About the application

Application number: 2025/92539	
What is the application for?:	Erection of detached dwelling with associated access and parking
Address of the site or building:	adj, 49, Hopton Lane, Upper Hopton, Mirfield, WF14 8JN
Postcode:	WF14 8JP

Drawn CJA
Date Jun 2025
Scales 1:100 @ A1
Drawing No. 2526 - 0301 - R01

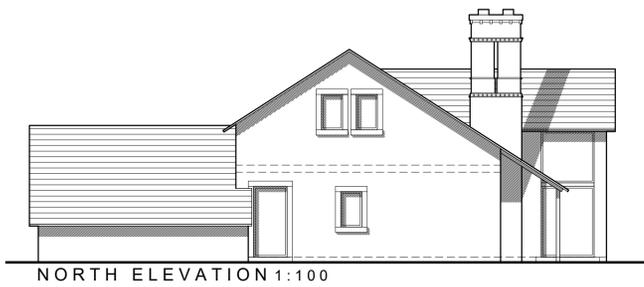
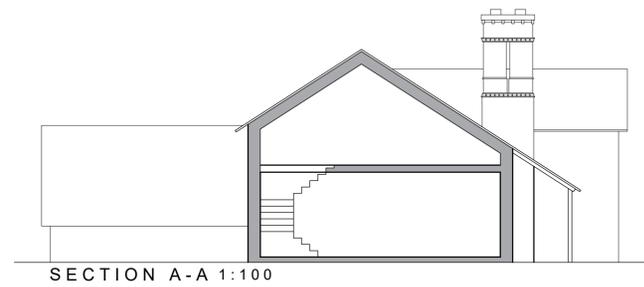
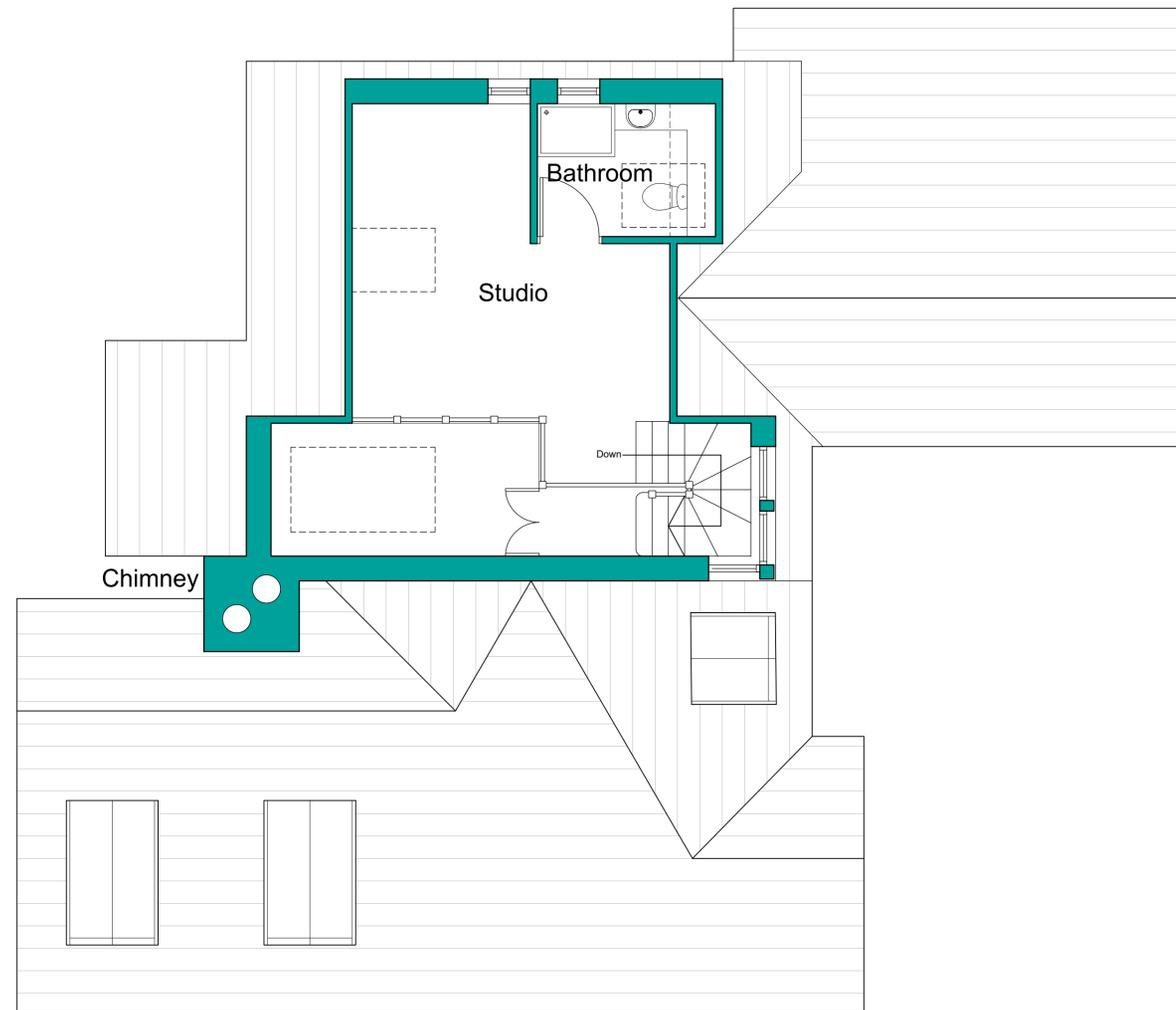
Type of comment: An objection	
Do you wish your comments to be published on the website anonymously?	Yes
<p>The building will be very intrusive being right next to my garden and directly overlooking this private area, as well as having windows directly facing my own which are also private. The building is too high comprising 2 floors. This will block daylight onto my property. There will be too much traffic going onto and off the already busy and dangerous road, Hopton Lane. Clearly this property will effect loacal amenities. The building will almost completely cover a large grass and planted area which in conjunction with my garden and others would disrupt the local wildlife including bats, hedgehogs, frogs and many other species. This building would also increase light and noise polution. It is next to trees with conservation orders and will undoubtedly impact on those. This propery would negatively impact on at least 10 properties.</p>
